**THE SIZEWELL C PROJECT**

**EN010012**

**Deadline 7: WRITTEN SUBMISSION OF ORAL CASE (ISH10) and  
EXPERT COMMENTS on ISH10**

**Figure 1.1**  
**Monitoring locations**  
**Site 54 Pakenham**

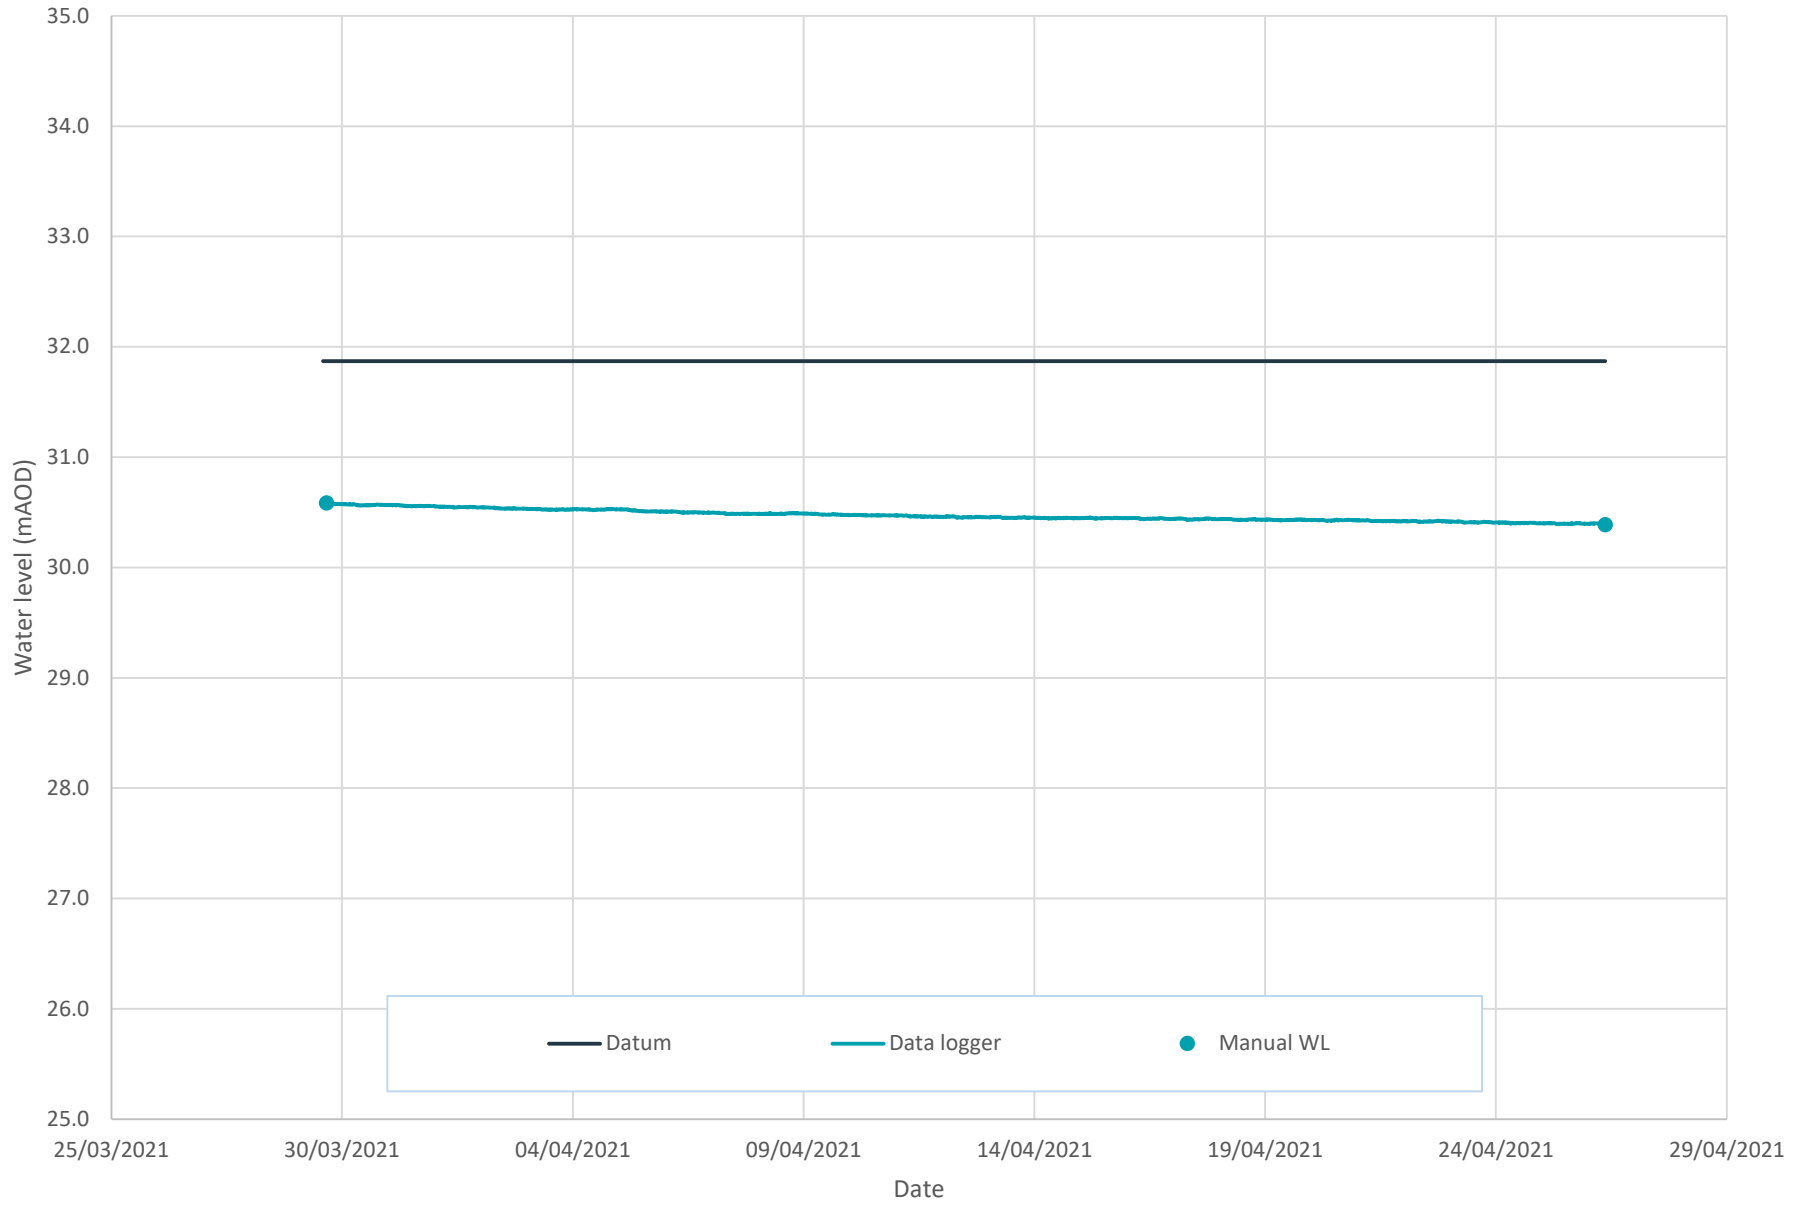
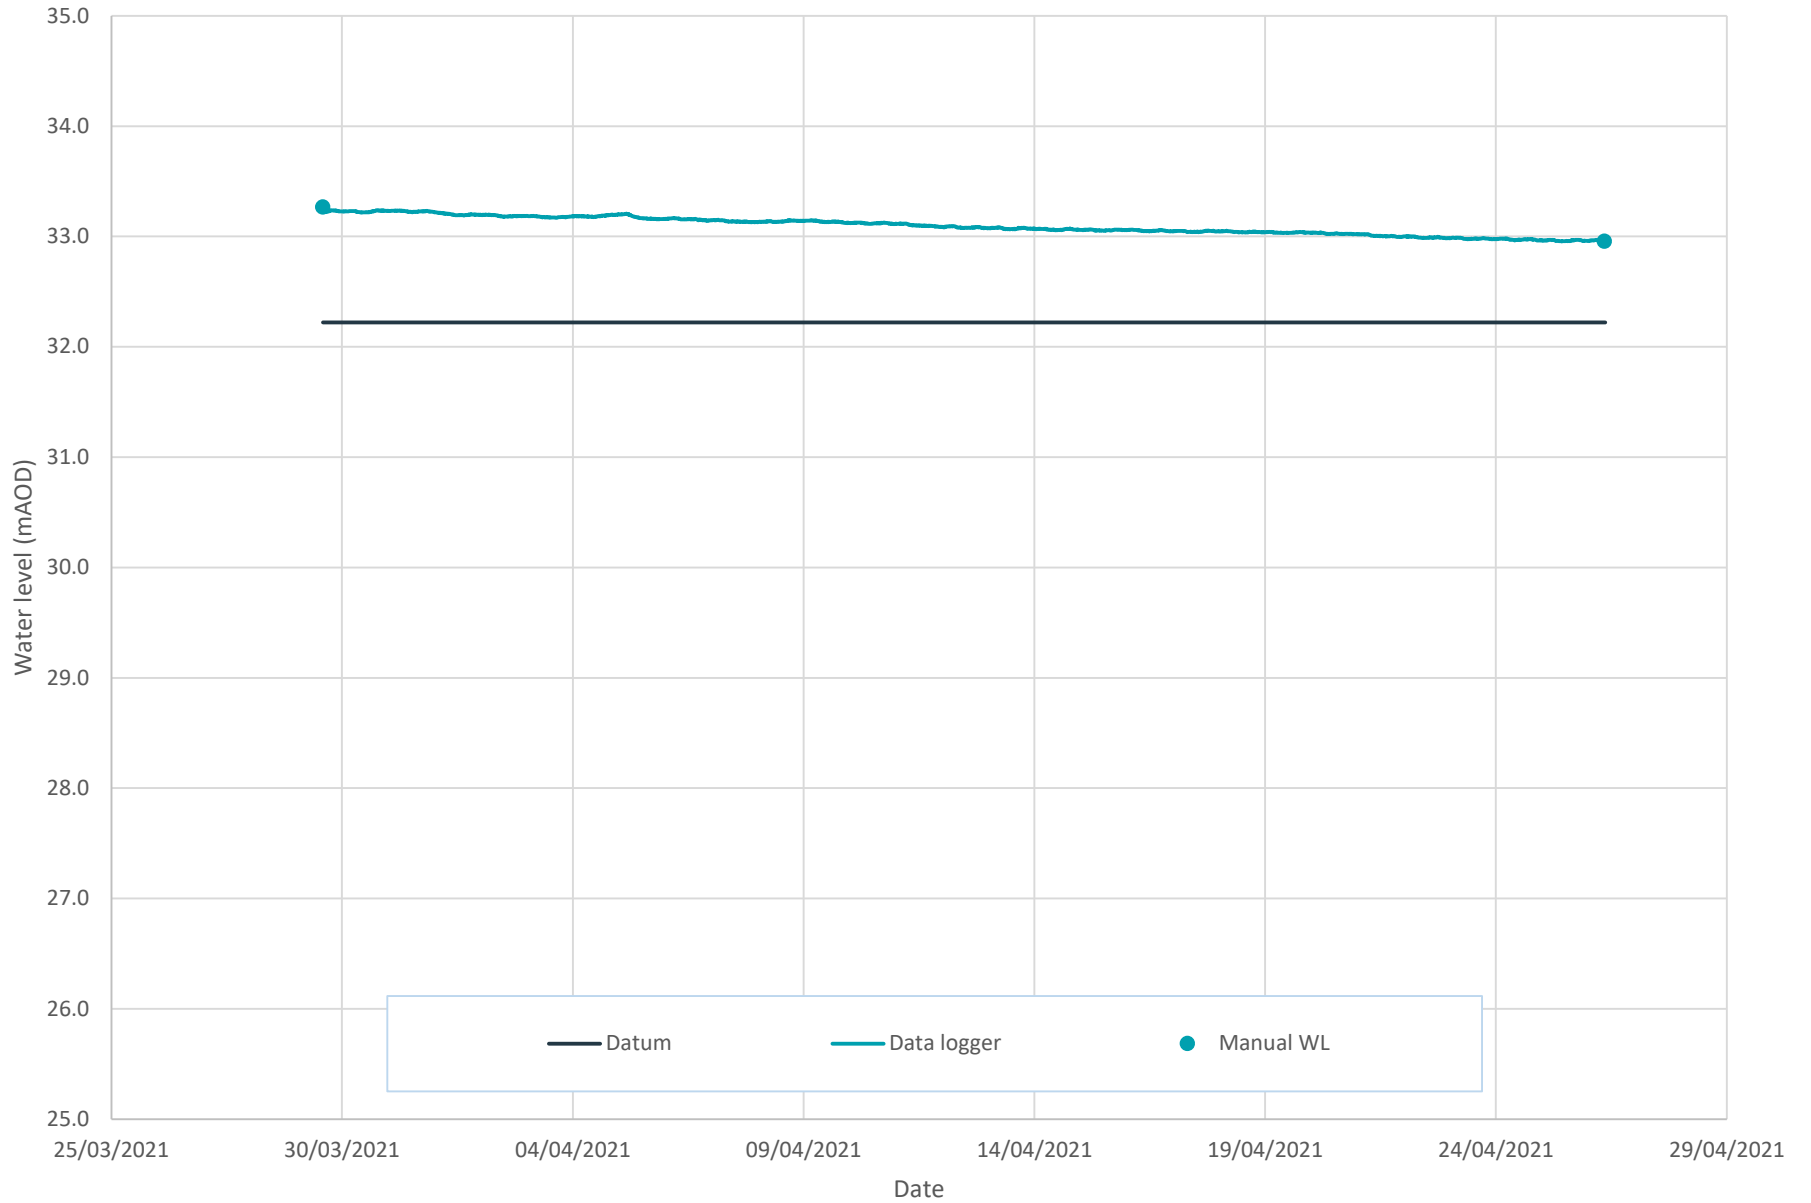
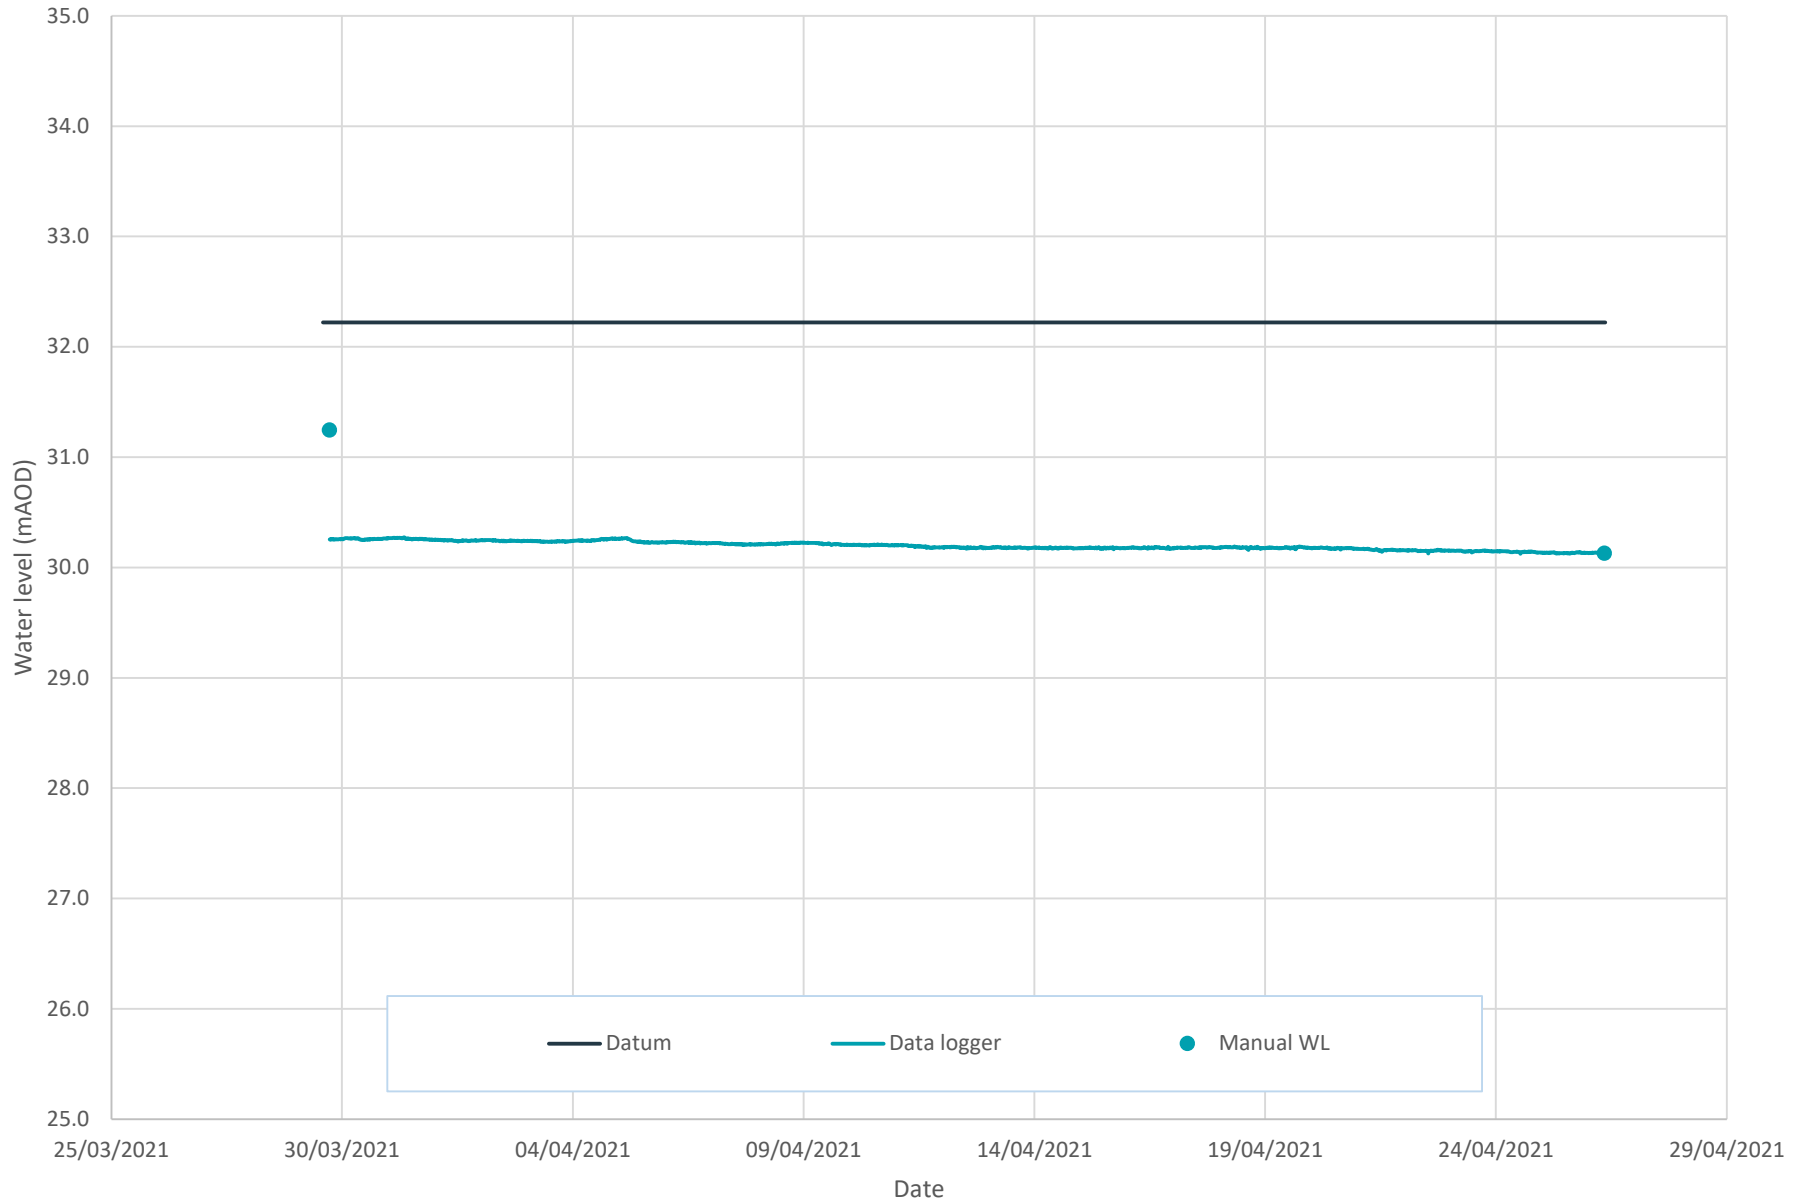
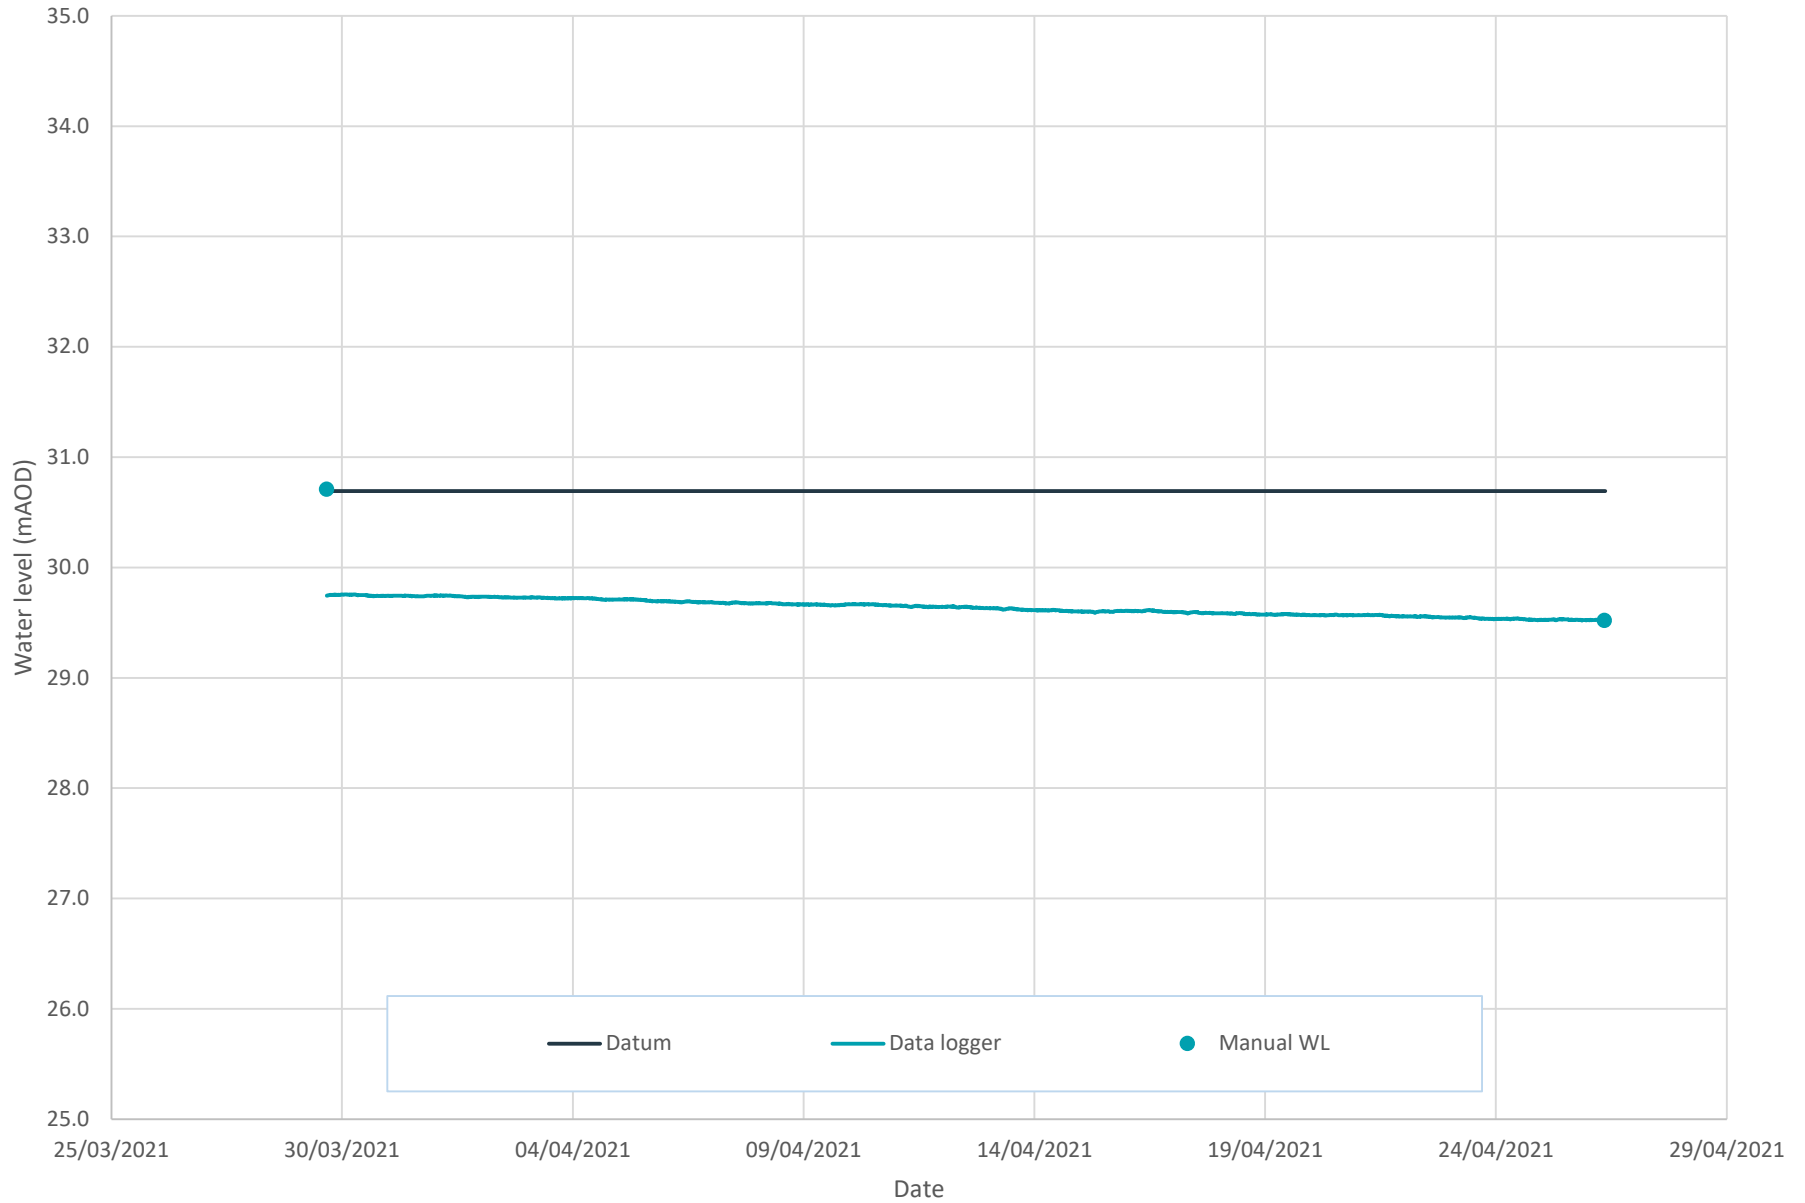
This assessment should have sufficient time to be fully reviewed and signed-off by the applicant’s consultants. The current submissions show significant signs of poor-quality collection and/or processing of water level data. Examples are on pages 261, 262 and 264 of PINS reference REP3-052 (full reference below), where there is very poor correlation of manual and logged data points, which has no associated explanation.

At Pakenham, there is a need for the third-party abstraction to cease, but there is no discussion around whether this is likely.

Again at Pakenham, we are concerned that water levels might be too low here for effective habitat creation in summer months. Wheeler *et al.* (2009) suggests summer water levels down to 1.75 mbgl are possible, but this is exceptional and in drought conditions and would not be expected to be observed in a short record outside drought conditions. Note that one month of “exceptionally dry” conditions (see above) does not constitute an established drought, and it is not considered that we are currently experiencing such an event. It is also important to note that if the restoration is
